Ref: 6/2022/2478/LB
Date: 13/03/2023

HISTORIC BUILDINGS AND CONSERVATION ADVICE

RE: 44 Fore Street, Hatfield, AL9 5AH

The application is for the replacement of 8 x rear facing windows and provision of 2 extractor vents at the rear of the site.

Drng. No
 894 / 02

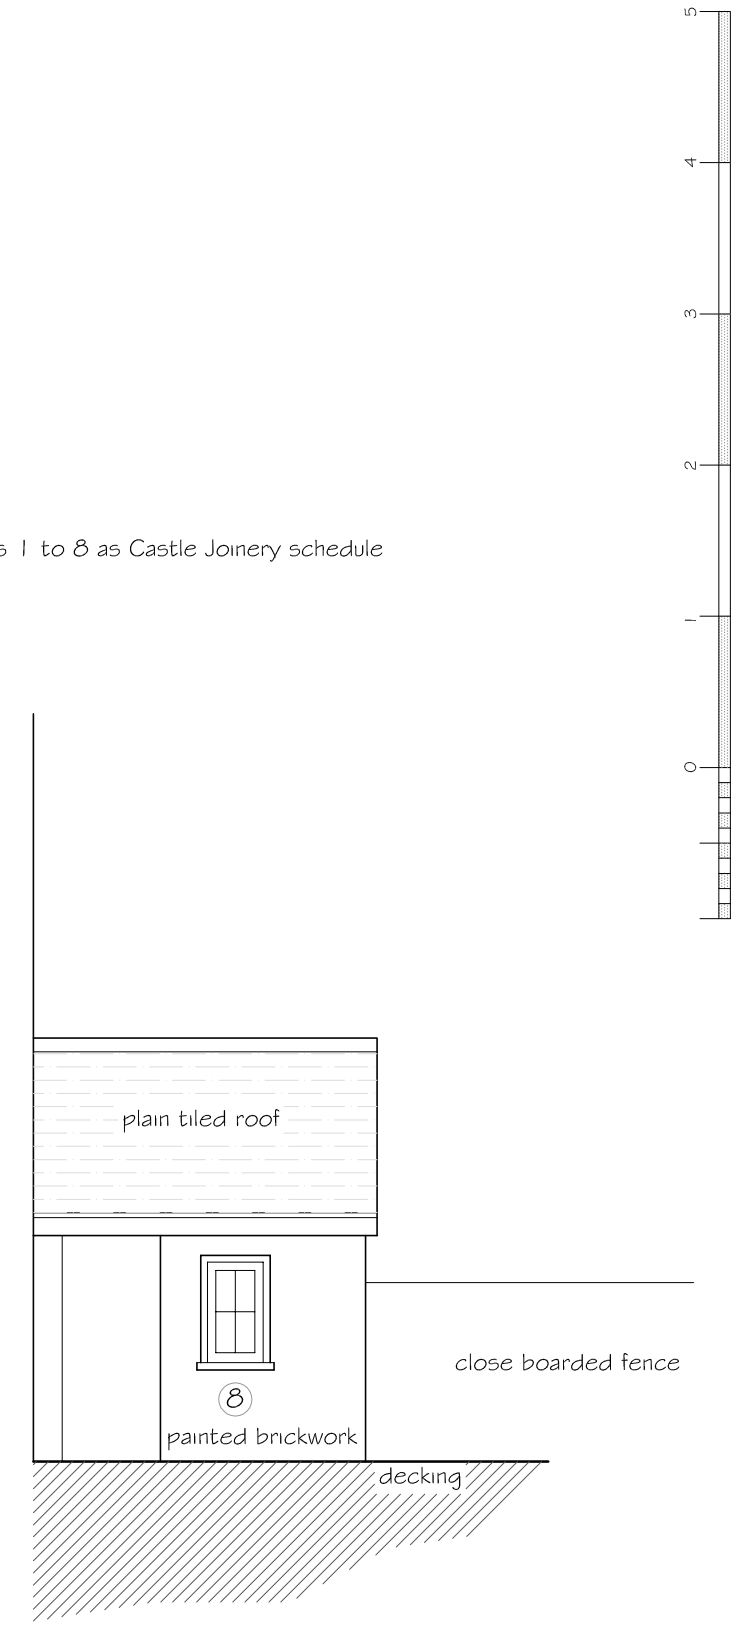
The proposed replacement windows have traditionally detailed timber frames and double glazed units. As per Historic England's guidance on *Traditional Windows: their care, repair and upgrading* (2017) the replacement of modern, poorly detailed windows with traditional well detailed double glazed windows is acceptable as the improvements in the design and detailing of the windows enhance the appearance of the building.

The details provided (including a section drawing provided by email on 25/01/2023) show flush fitting casement windows and integral glazing bars with a putty finish. Window no.1 (bathroom, second floor) is to be a five-over-ten sash window due to the proportions of the aperture. The double glazing units proposed are approx.. 15mm in thickness and will improve the sound and thermal insulation. The spacer bars will be white rather than the standard silver to improve the appearance of the windows. It is recommended that the putty is white in colour of painted white to match the frames.

The windows are traditionally designed without trickle vents. In regards to the impact on the significance of the listed building, the omission of trickle vents is fully supported. Approved Document F notes that the standards for ventilation should be complied with as far as they can without unacceptably affecting the significance of listed buildings. It should also be noted that the building is of breathable construction which has been enhanced with the recent re-plastering of the interior in lime plaster.

In addition, two extractor vents are proposed to be installed at first and second floor level on the rear elevation. This is uncontentious as the loss of historic fabric is minor and they will allow the bathrooms to be ventilated.
